Objections submitted in response to East Pye Solar

PINS Reference: EN0110014

Land Parcel 6

Submitted by BEPS (Block East Pye Solar

Figure 4.2: Indicative Temporary Construction Compound Locations

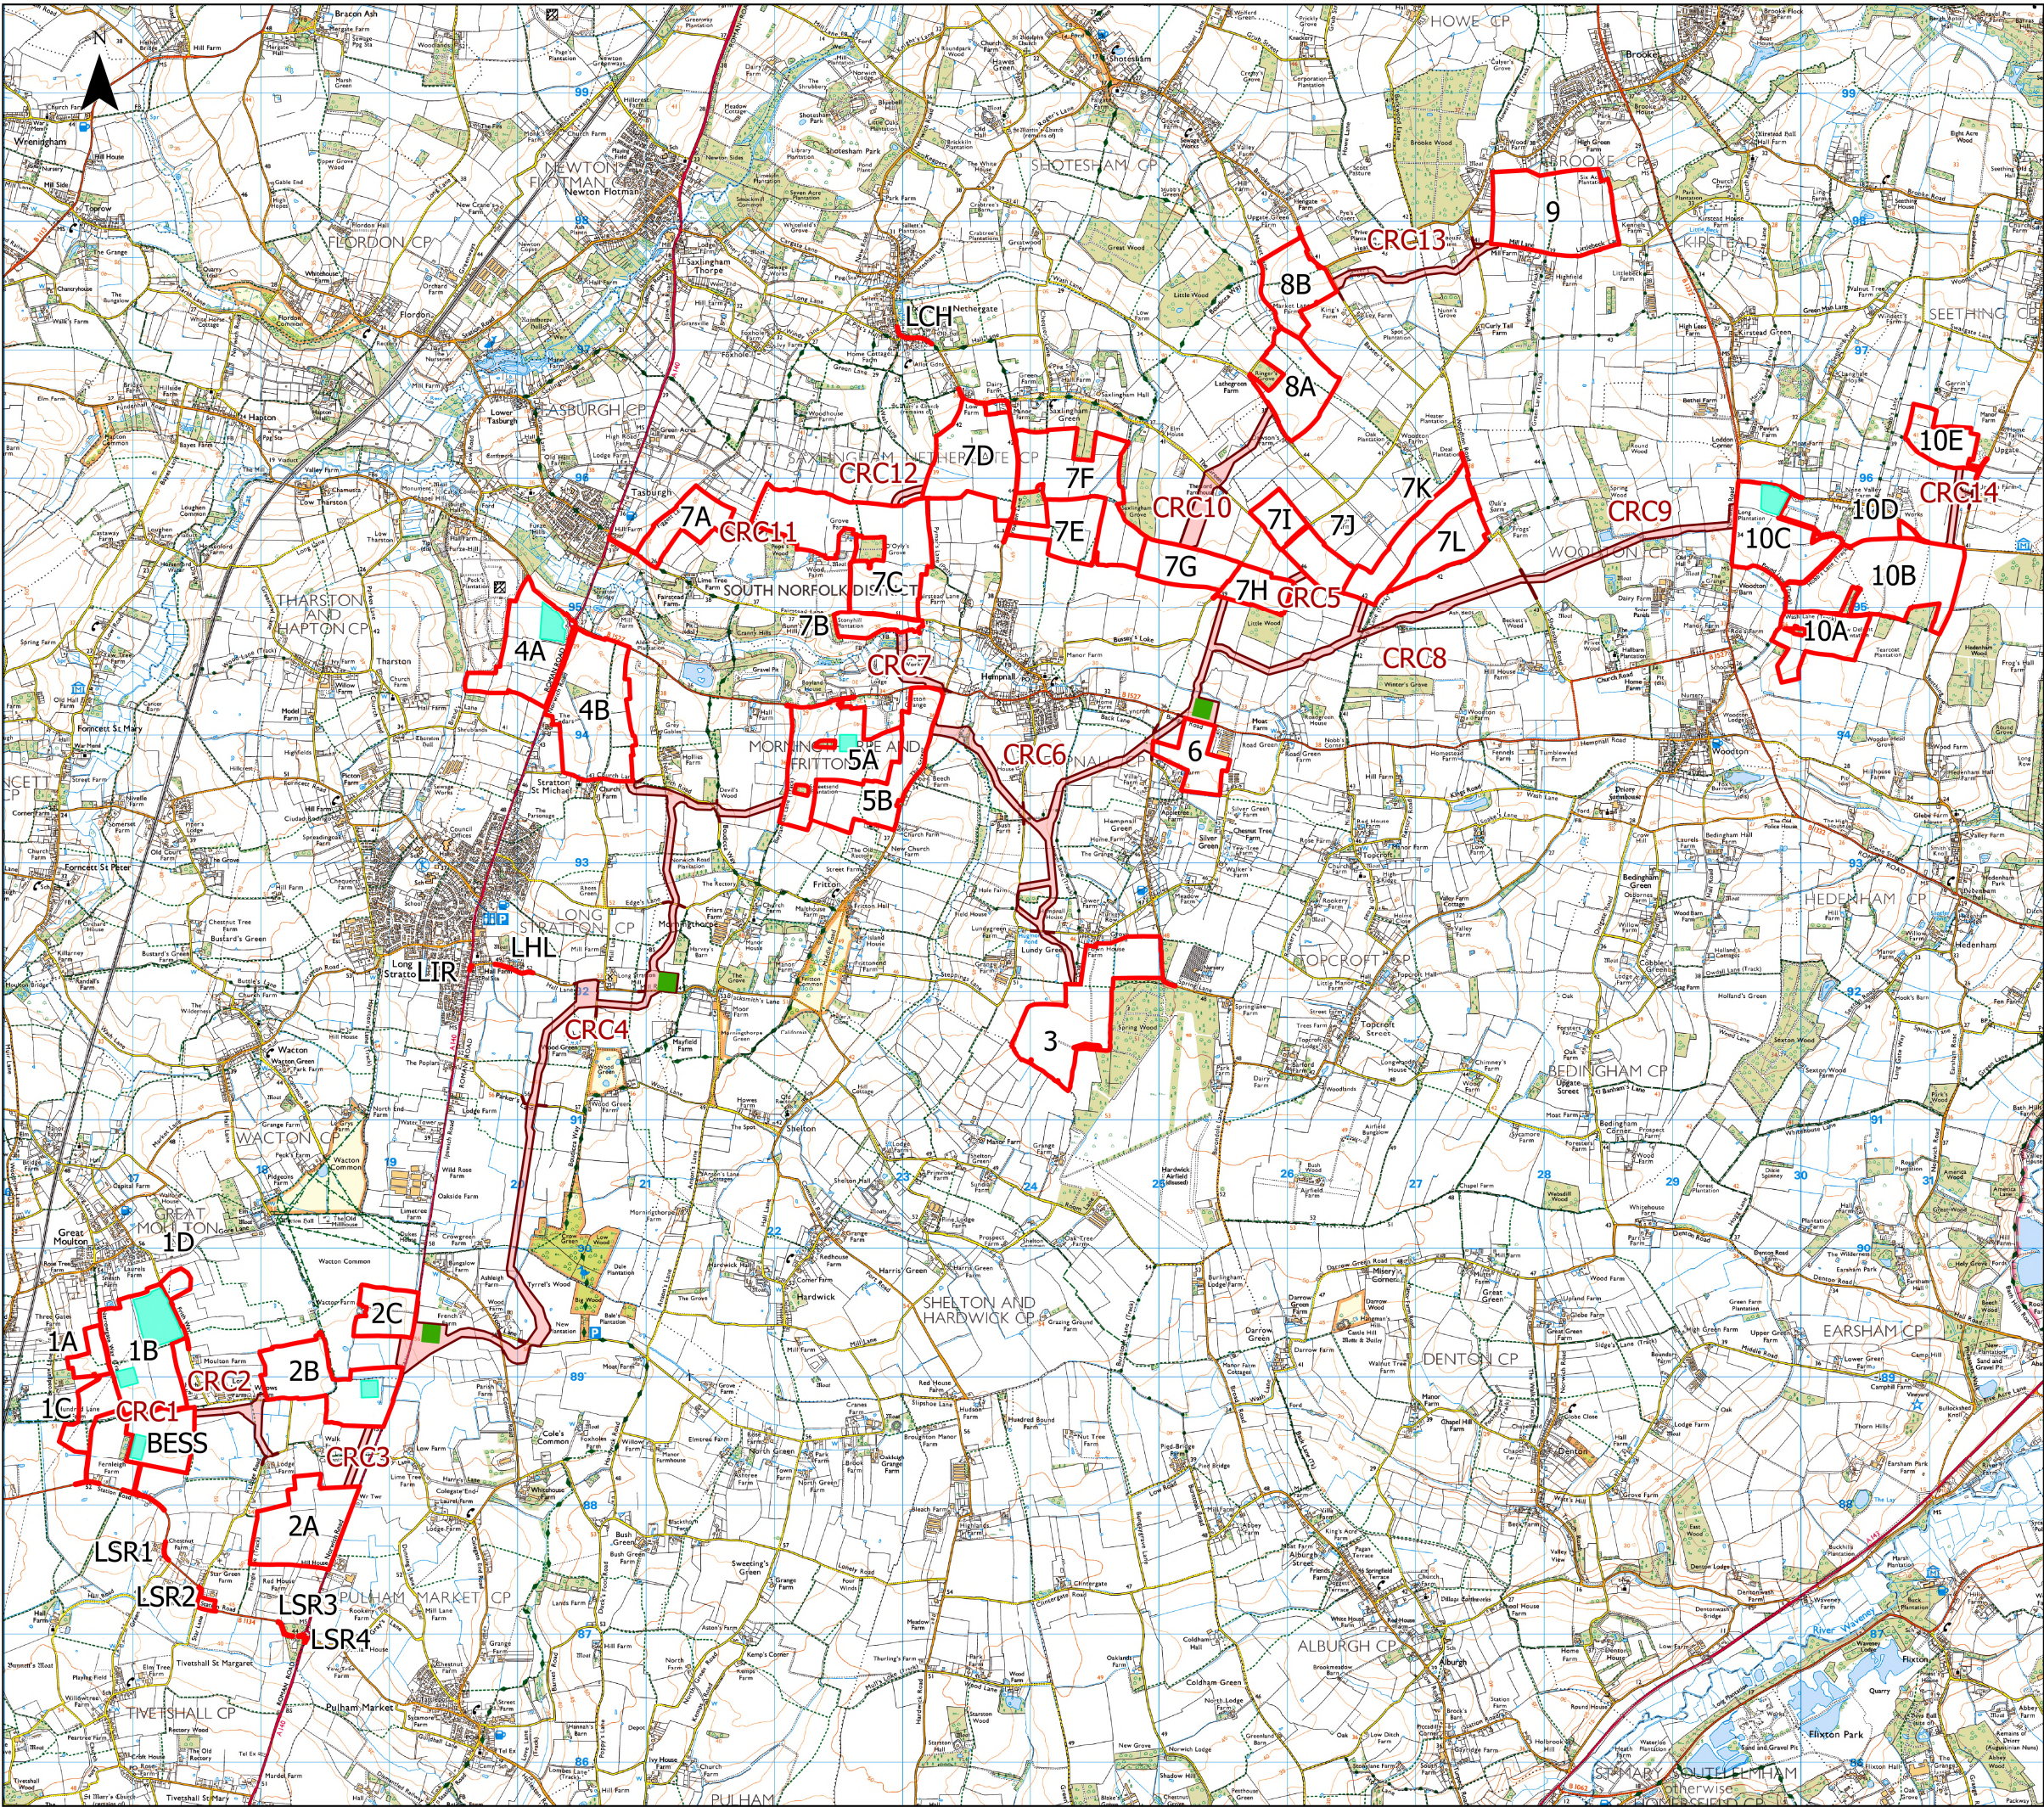
Land Parcel 6 is **undeliverable in principle**. The Applicant relies on this parcel simultaneously as a **construction compound** (with heavy plant, storage, traffic and disturbance) and as **ecological and landscape mitigation land**. These roles are **mutually incompatible** and expose a fundamental internal contradiction within the scheme.

It is not clear how site 6 will be developed as a construction compound – for example, whether it will be tarmaced for vehicle access, whether buildings will be constructed on it or storage compounds. It is unclear how contamination, compaction and other changes to this site caused by its use as a construction compound will be remedied in order to convert it into a biodiversity mitigation area.

The impact on the surrounding Grade II* and Grade II Listed Buildings of this development of the land as a construction compound should also be assessed. If diesel generators are used or other potential fire hazards, this could have a serious impact on the timber-framed and thatched listed buildings which surround this site. No risk assessment has been carried out. Equally the vibration caused by HGVs in close proximity to these fragile buildings without modern foundations, and changes to water infiltration on the field caused by making it capable of carrying traffic, may also have a detrimental affect on the surrounding listed buildings. This has not been assessed.

It is also unclear whether site 6 will be reused as a construction compound again during the lifetime of the project for replacement of solar panels. This would destroy any BNG benefit. It would again have an impact on the surrounding Listed Buildings.

Land Parcel 6 is bordered along its southern edge by approximately **20 residential properties** on Silver Green (formerly Furze Lane). Some dwellings lie **as close as 60 m** to the parcel boundary, with a farm bungalow less than **20 m** from the north-eastern edge.

There are **three listed buildings within 100 m** of the southern boundary of Land Parcel 6:

Evidence of water pooling along the northern edge of the parcel demonstrates poor drainage and heightened sensitivity to compaction and runoff.
